BCA ASSESSMENT REPORT

**Aspect Industrial Estate
Lots 54-58 Mamre Road, Kemps Creek
Warehouse 1 (Lot 1)**

**Prepared For:
Mirvac**

Revision 52

WAREHOUSE 1	
Site Area	61,039 m ²
Offices	900 m ²
Warehouse	32,686 m ²
Dock Office	300 m ²
Total GFA	33,886 m ²
Carpark Provided	167

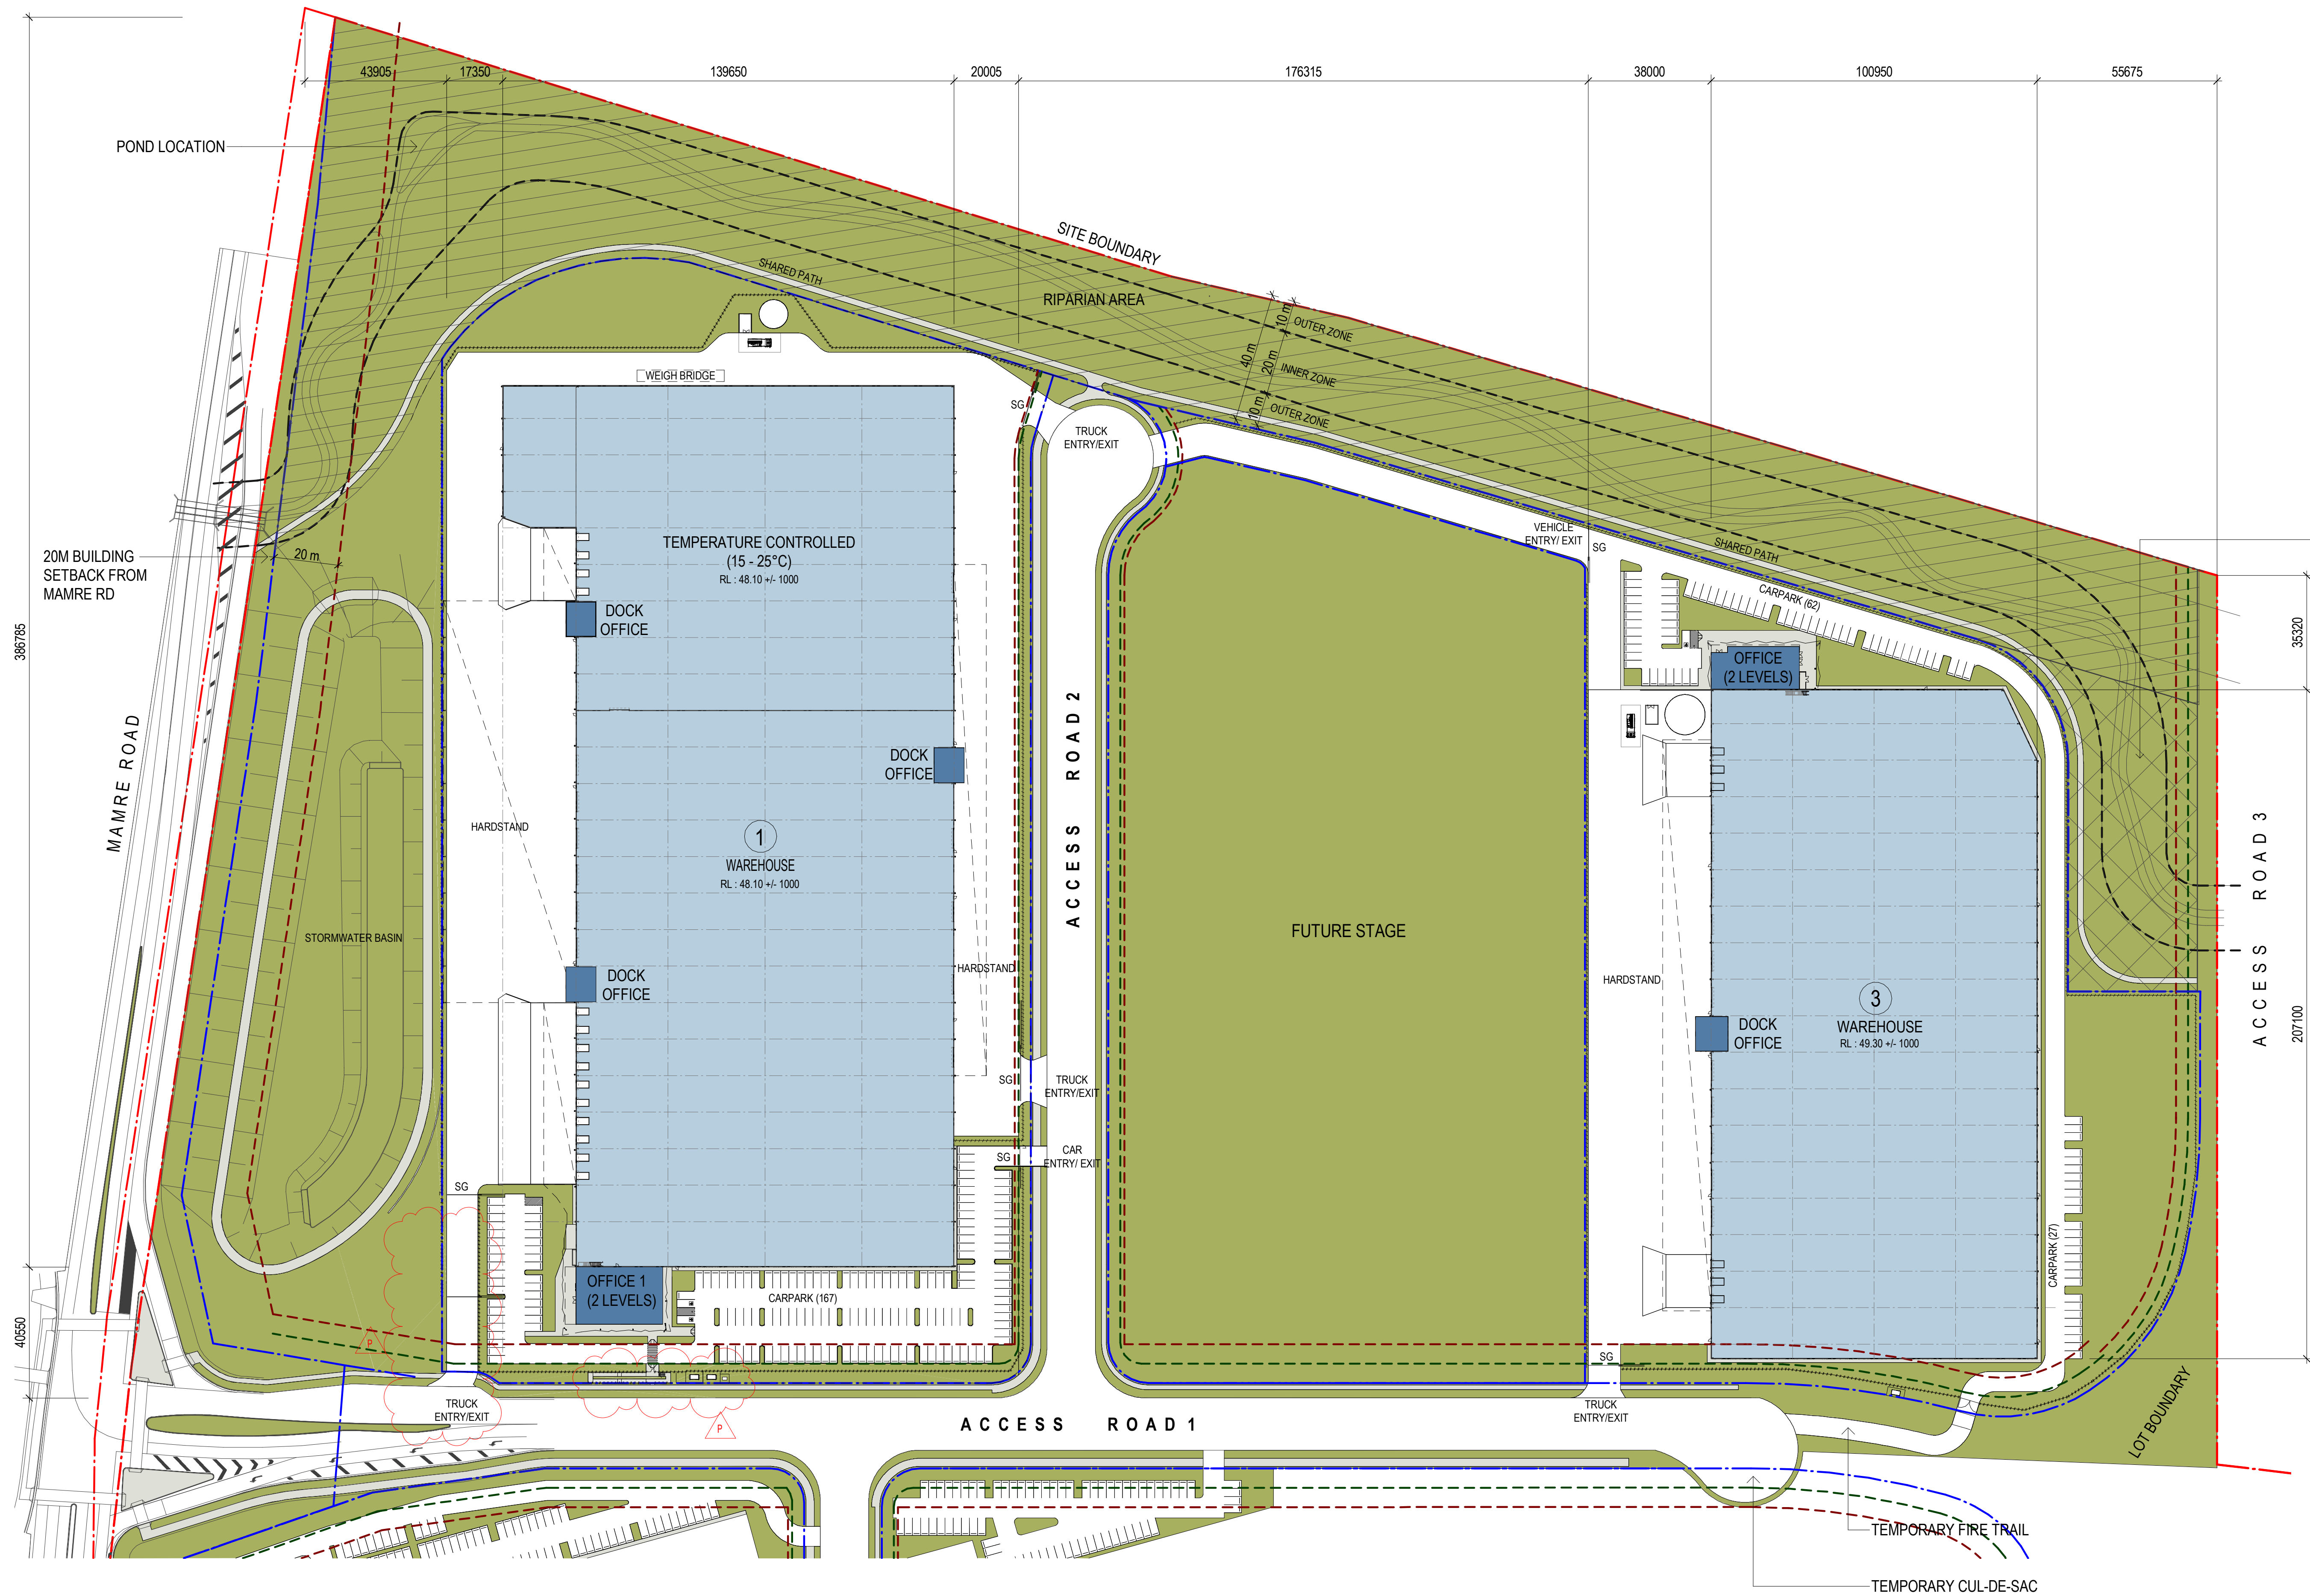
Comments: The proposed building does not comply with the provisions of C2.4 and thus the following non-compliance issues are required to be addressed as a Performance Solution by the Fire Engineer to demonstrate compliance with Performance Requirement CP9:

- + *Perimeter Vehicular Access is greater than 18m from various parts of the building.*
- + *Perimeter Vehicular Access requires traveling under the super awning on the western side of the building.*

Note 1: Any proposed gates are to achieve no less than 6m unobstructed width or the reduced width will need to be included in the above Performance Solution.

Note 2: The driveways providing vehicular perimeter access must be designed with adequate loading capacities to withstand a fire truck and the gradients of any ramps and swept paths should take into consideration the requirements of the FRNSW Fire Safety Guideline – Access for Fire Brigade Vehicles and Firefighters.
